SHARON VIEW COUNTRY CLUB

CHARLOTTE - MECKLENBURG PLANNING COMMISSION
 INTER - OFFICE COMMUNICATION

DATE: October 15, 1997
 FROM: Martin R. Cramton, Jr. Planning Director
 TO: Robert Brandon Zoning Administrator
 SUBJECT: Administrative Approval for Petition No. 96-12 by Christopher J. Branch/The Boulevard Company Tax Parcel # 183-153-99 and 183-141-08

SHARON VIEW COUNTRY CLUB

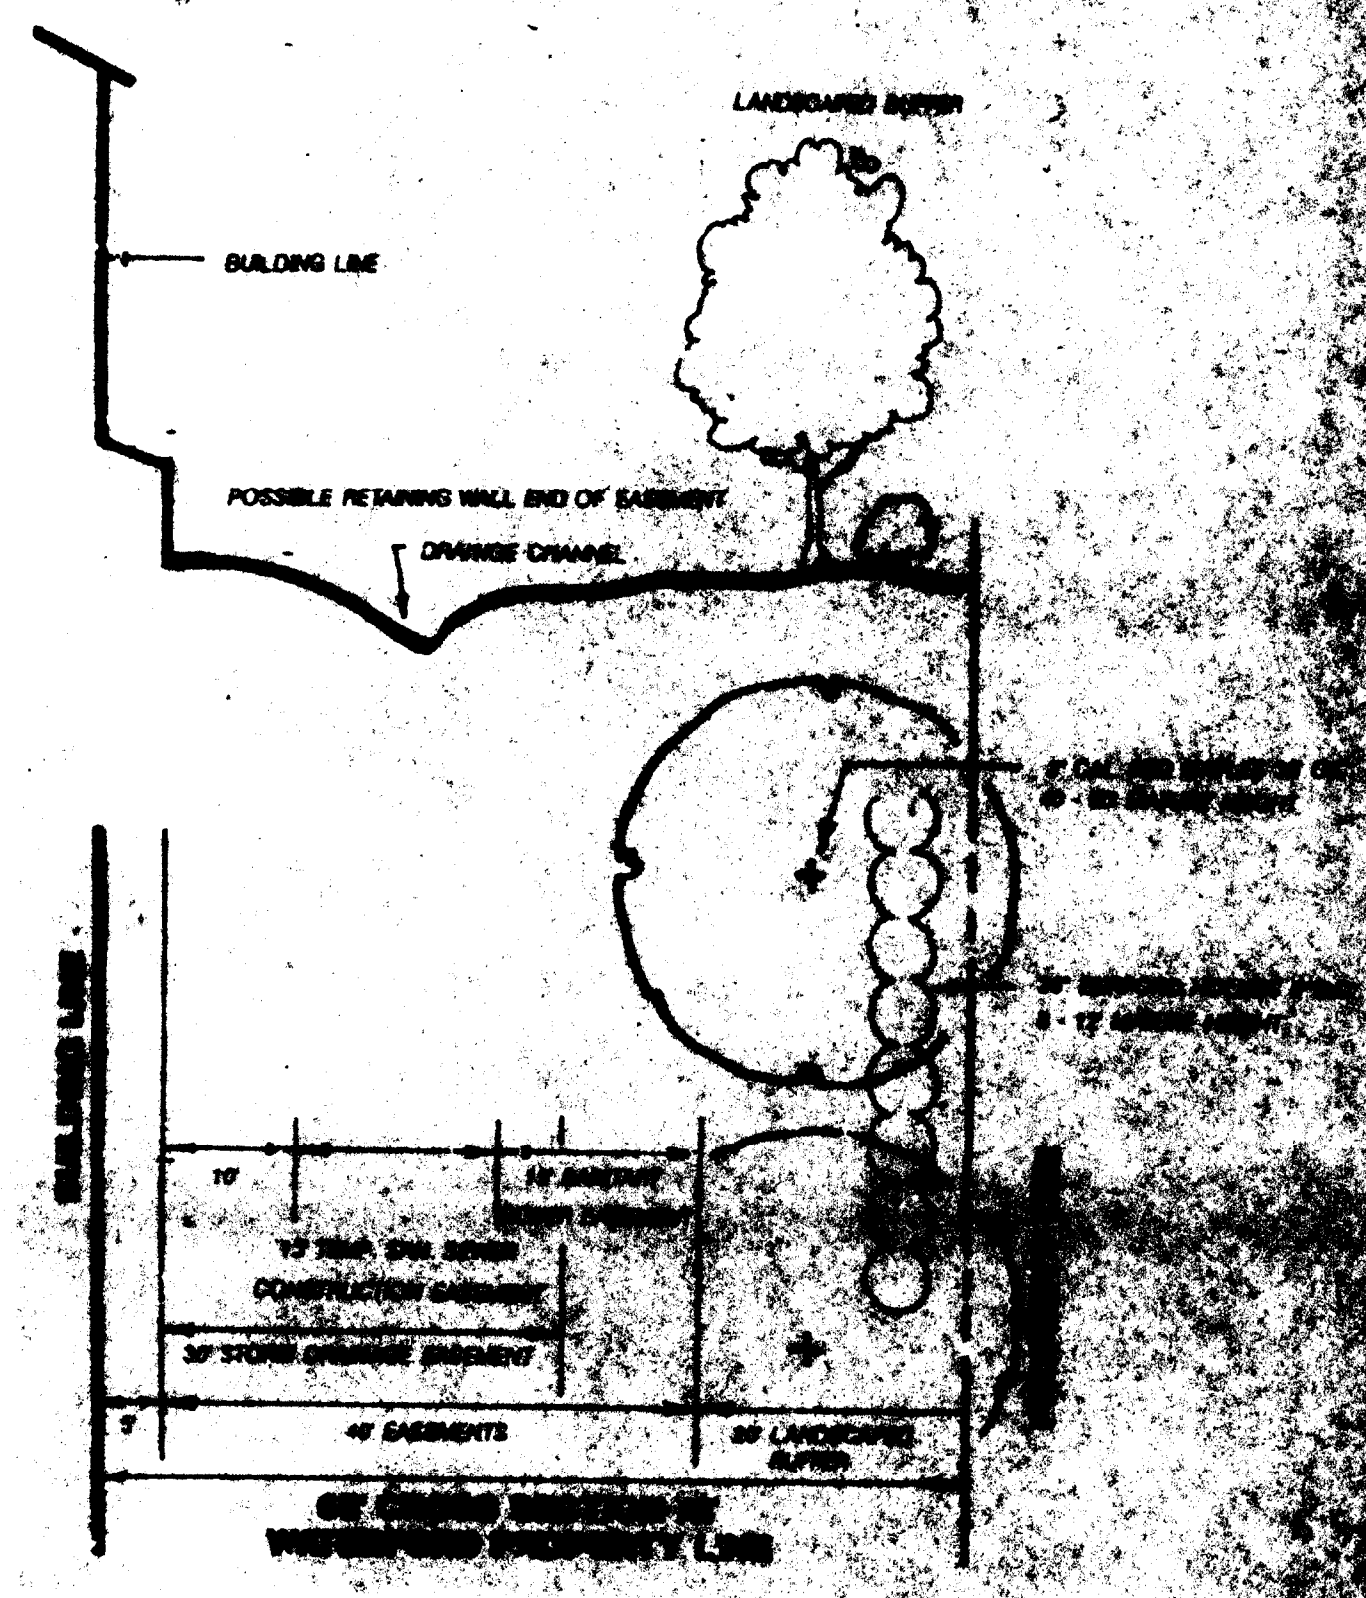
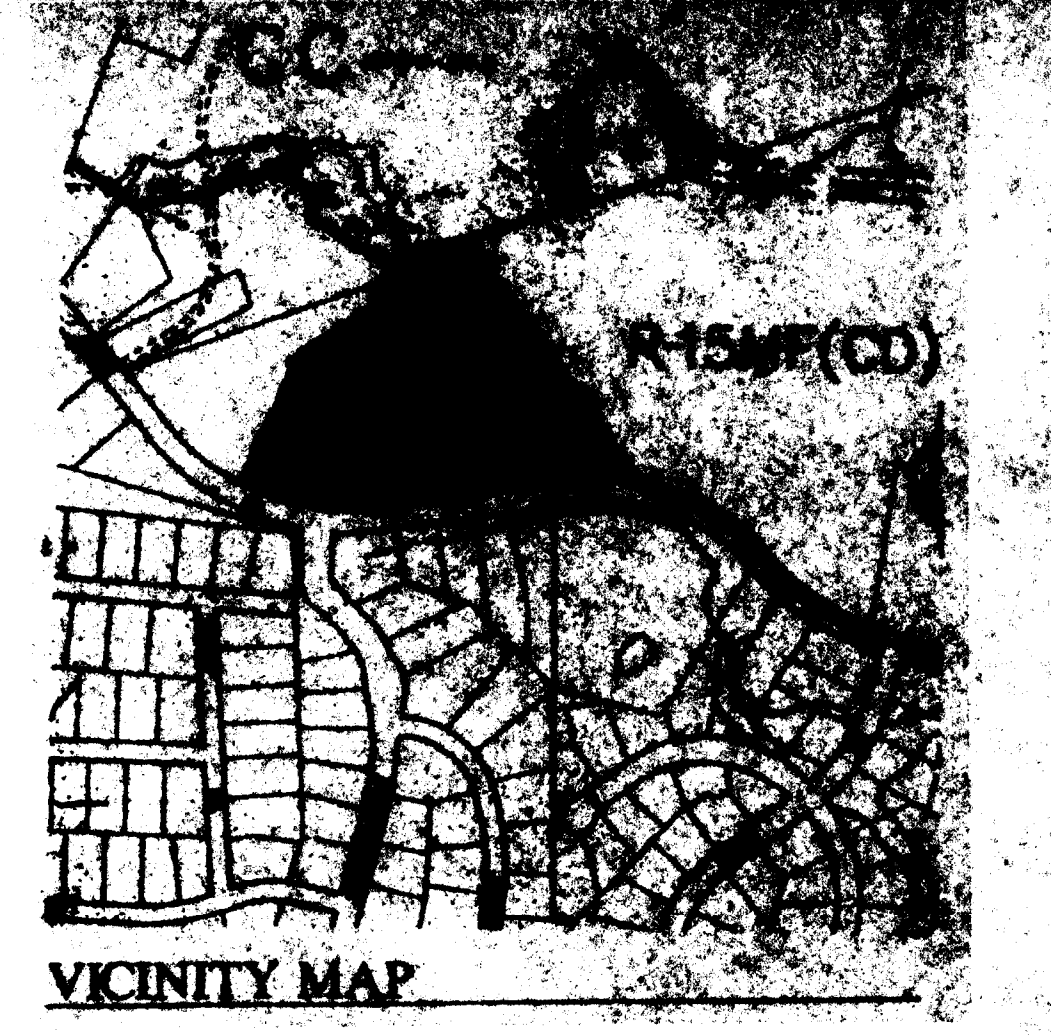
Attached is a revised plan for the above mentioned rezoning petition. The plan has been revised to allow a delay in the construction of the required left-turn lane along Sharon View Road. The left turn lane will be constructed as part of a City widening project scheduled for the area.

The currently approved conditional plan for this site requires that a left turn be constructed before a certificate of occupancy is issued. This would require the construction of the left turn in during the next 12 months. However, the City has a funded widening project for Sharon View Road that would start construction within the next two (2) years. This widening project would require the removal and reconstruction of the left-turn improvements constructed by the developer. Therefore, in order to avoid the construction, removal and re-construction of the left-turn lane we are administratively allowing the developer to delay the construction of the left-turn lane so that it may be constructed by the City, at the developers expense, as part of City's project.

September 23, 1997
 Left hand turn lane to be provided by CDOT as part of Sharon View Road widening. Developer to pay for the cost of left turn lane. In the event that CDOT does not start construction of road widening project within 1 year of when developer commences construction, then developer will be responsible for construction of left turn lane. The plans submitted for approval will not have left hand turn lane as part of plans. However, in order to be prepared for construction of left turn lane should CDOT not begin road widening project within a year of developer commencing construction, developer will submit plans for left hand turn lane within 60 days of addresses being issued and will get plans approved prior to issuance of the first certificate of occupancy. The final certificate of occupancy will be contingent upon the city or the developer starting construction of road widening or left hand turn lane respectively. A bond for the left turn lane improvements will be posted with City Engineering prior to the issuance of the first certificate of occupancy.

The developer will be responsible for preparing and getting approval of a set of plans for the construction of the left-turn lane prior to the issuance of a certificate occupancy. In addition at the time the left turn lane design is approved a bond for its construction must be posted with City Engineering. If the City project to widen Sharon View Road has not commenced within one year after the first Certificate of Occupancy is issued for the site the developer must then start construction of the left turn lane. The certificate of occupancy for the last building in the project may not be released until the left-turn lane is constructed. The bond for the left turn lane may not be released until the left-turn lane is constructed.
